From: PDCA [pdimberline@tiscali.co.uk]
Sent: 09 February 2018 07:42
To: 'Technical_Sewerage@yorkshirewater.co.uk'
Subject: 12 Westfield Street, Barnsley S70 6EZ Sewerage Consultation on R138776
Attachments: Westfield Street YW932.pdf; Westfield Street931.pdf; Westfield Street TOPO 2014 23 06-Layout1.pdf

12 Westfield Street, Barnsley, S70 6EZ - Sewerage H4 Consultation on R138776

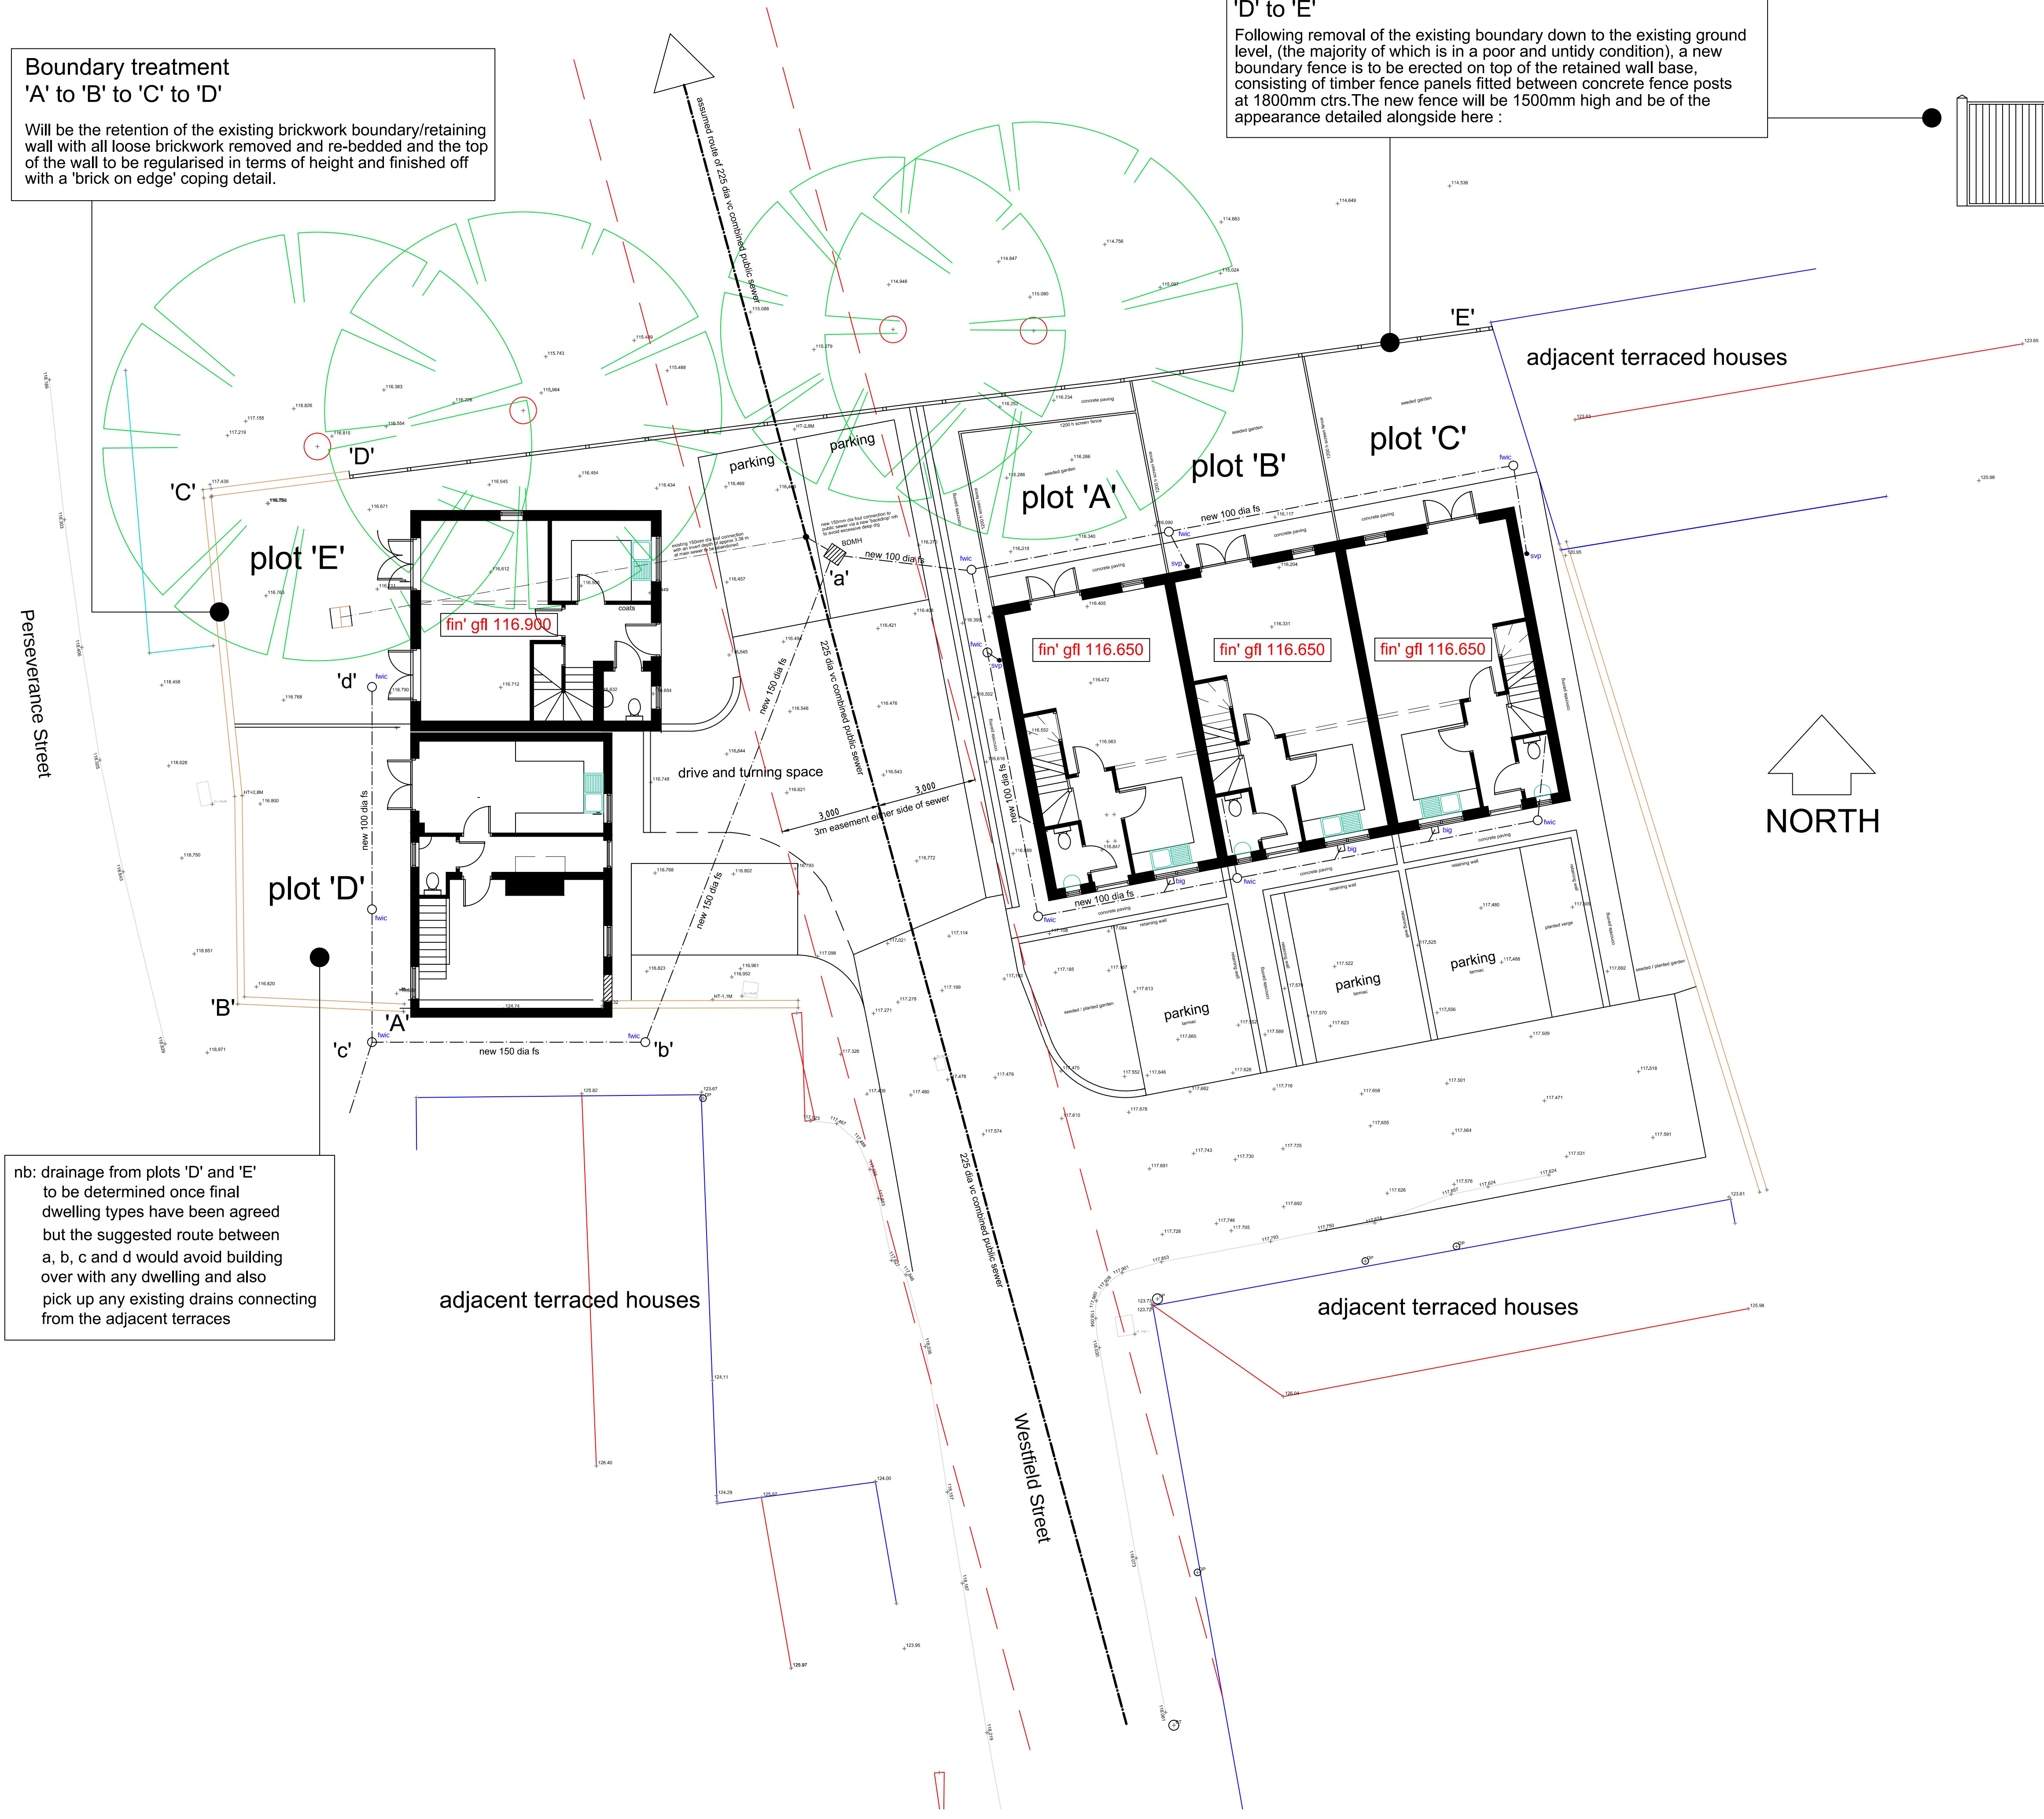
We have received a consultation from Building Control as part of the application for the works proposed at the above address. **There is a deep combined sewer running across the site with a 3m easement either side.**

Please provide plans clearly showing the existing and proposed drainage on this site, along with the footprint of the building to technical.sewerage@yorkshirewater.co.uk.

Thank you for your email. You'll have to demonstrate the site constraints on plan to discount soakaway. As a last resort yes sw can go to public sewer and the rate of discharge should be 70% of the proven existing. That reduced 1 in 1 rate should apply upto and including 1 in 100 plus climate change.
